CITY OF ALBUQUERQUE

**RE: Weinerschnitzel
1400 Gibson Blvd SE
Grading Plan
Engineer's Stamp Date: 7/17/18
Hydrology File: L15D049**

Based on the submittal received on 7/18/18, the grading plan is approved for Foundation Permit Only.

SECTION A-A

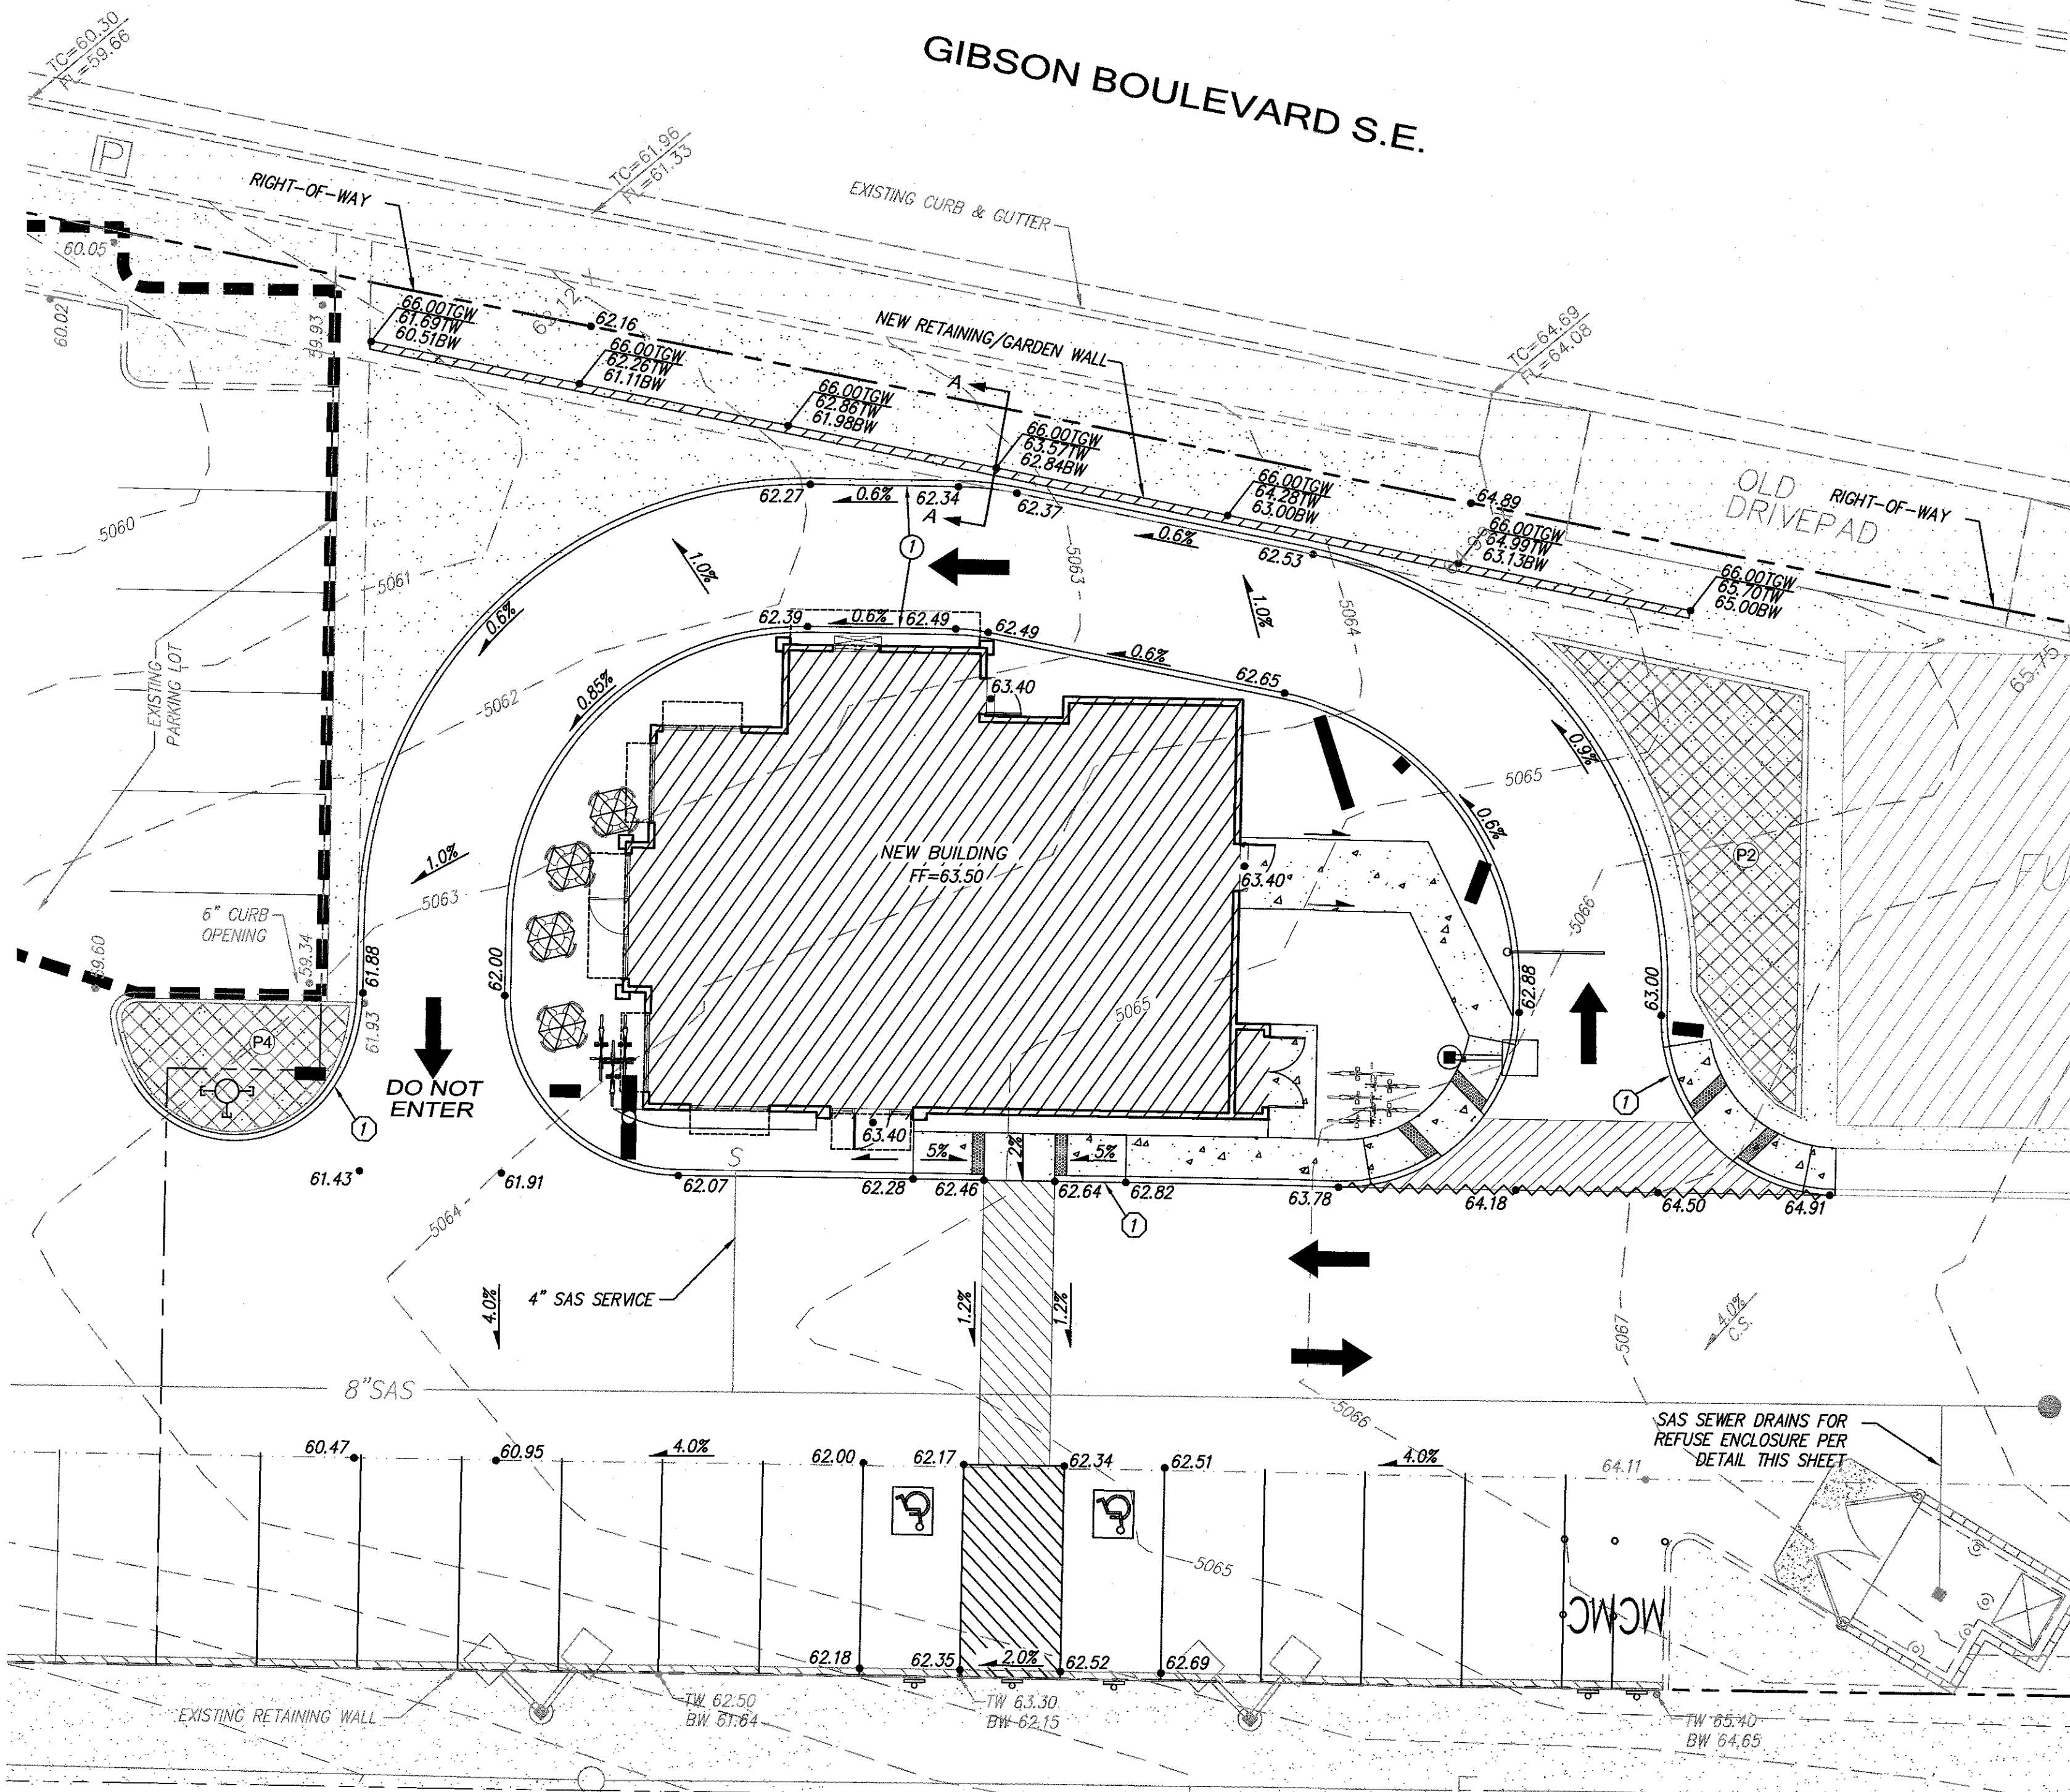
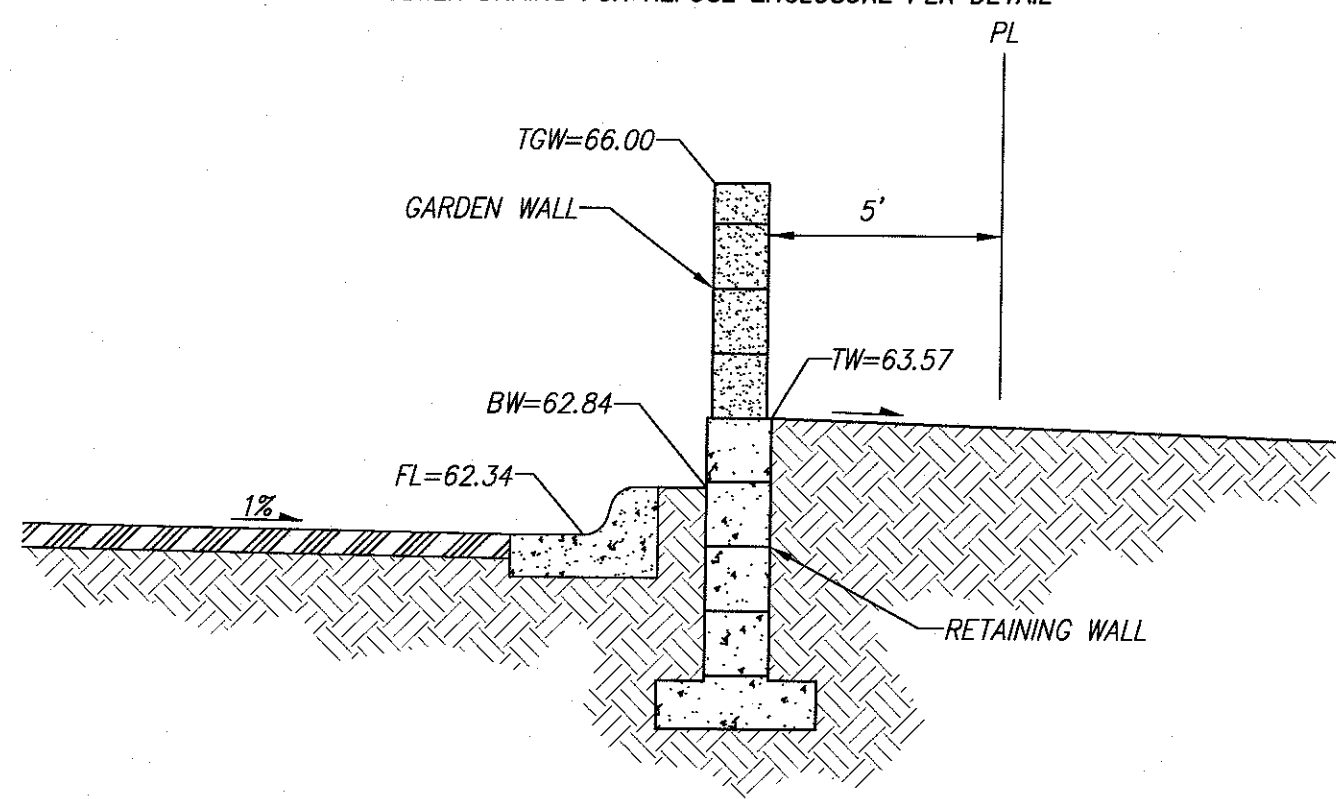
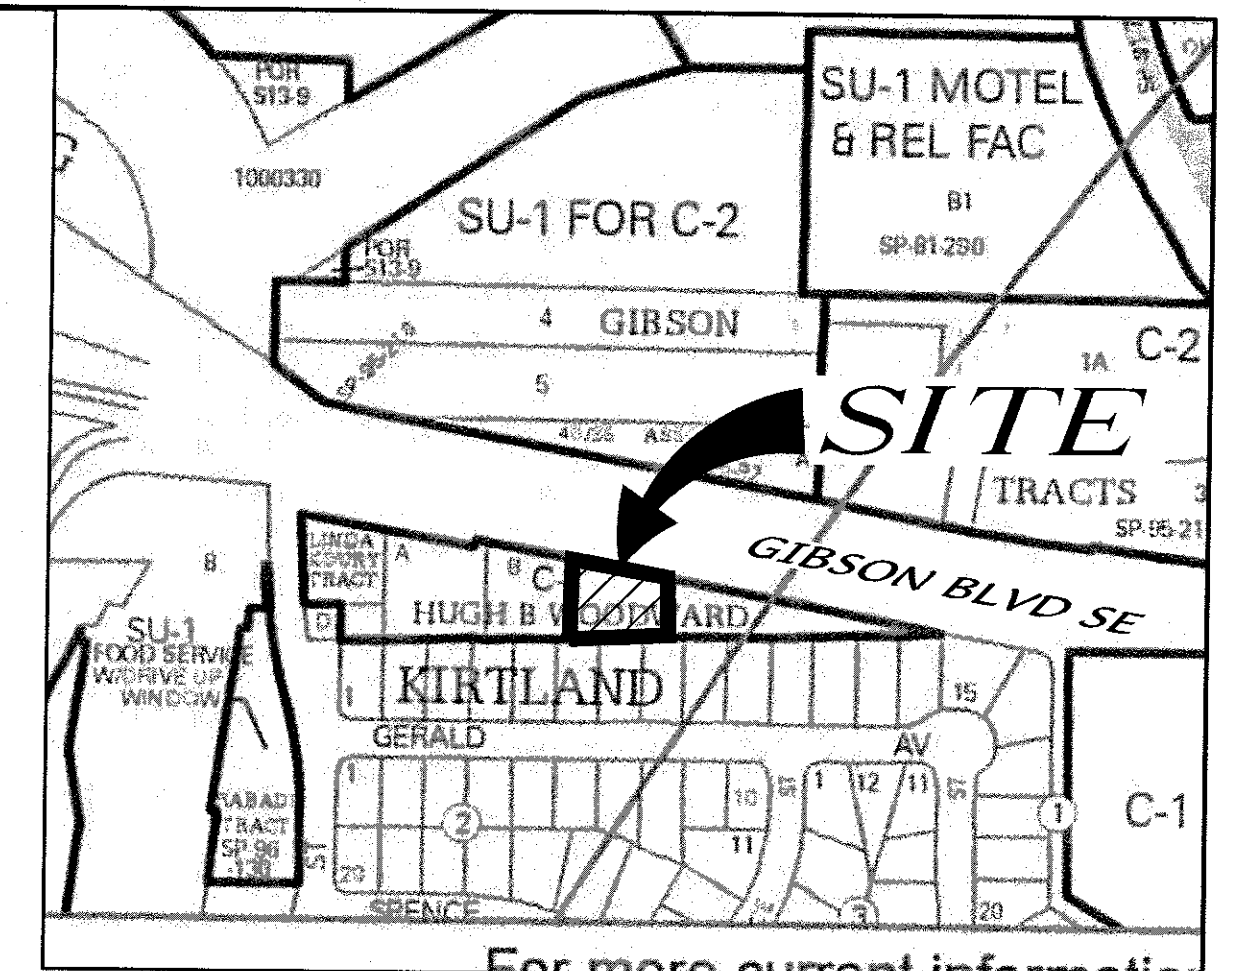
1. Show and label the ROW line on the plan view and the wall section. Any private encroachment into the public ROW by the retaining/garden wall or its footer requires a revocable permit. The complete permit and fees must be turned into DRC (4th, Plaza del Sol) for routing. Please contact Charlotte LaBadie (clabadie@cabq.gov, 924-3996) or Madeline Carruthers (mtafoya@cabq.gov, 924-3997) regarding the routing and recording process for revocable permits.

SANITARY SEWER DRAIN FOR REFUSE ENCLOSURE

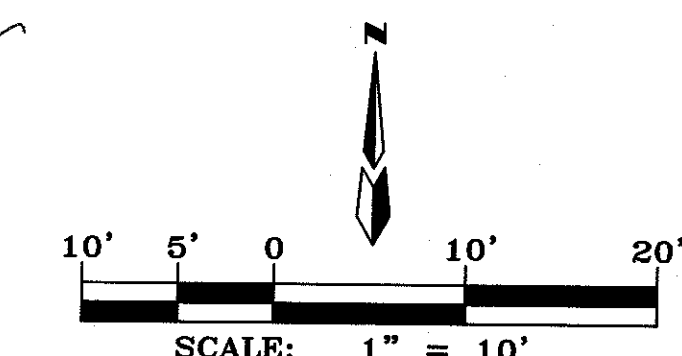
2. For trash enclosures serving food service developments, demonstrate *control of liquids from dumpster areas* per DPM Chapter 22.9.E, Table 1 by containing runoff from the dumpster area and discharging to the sanitary sewer. If this information is on the utility plan please provide it, or show on the grading plan.
